From: Aldingbourne Parish [REDACTED]
Sent: 14 June 2019 21:50
To: Nicola Spencer
Cc: Planning.Responses; Planning
Subject: Objection re Applications AL/42/19/PL and AL/43/19/L

AL/42/19/PL AND AL/43/19/L

Aldingbourne Parish Council wishes to note its objection regarding the above planning applications on the following basis:

Pigmento Red Zinc

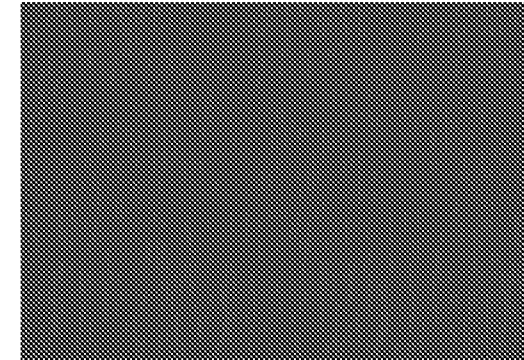
proposal to be set next to 'character' and 'listed' buildings - this council feels the proposed red zinc material is particularly out of character,

Traditional Flint Wall

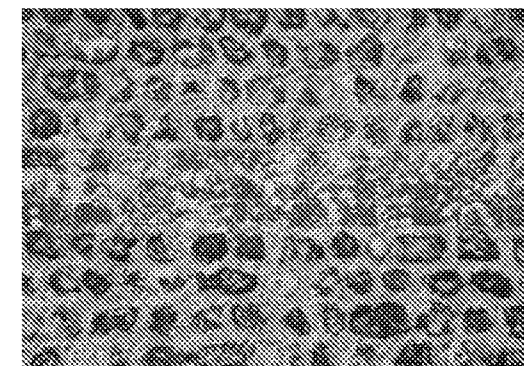
3) EH11 - this policy seeks to protect flint walls within the Parish. This current planning proposal will however obliterate the view of the existing 3m high flint wall; and the proposed modern construction (which will be sited very close to that wall) fails to sympathetically reflect the flint character.
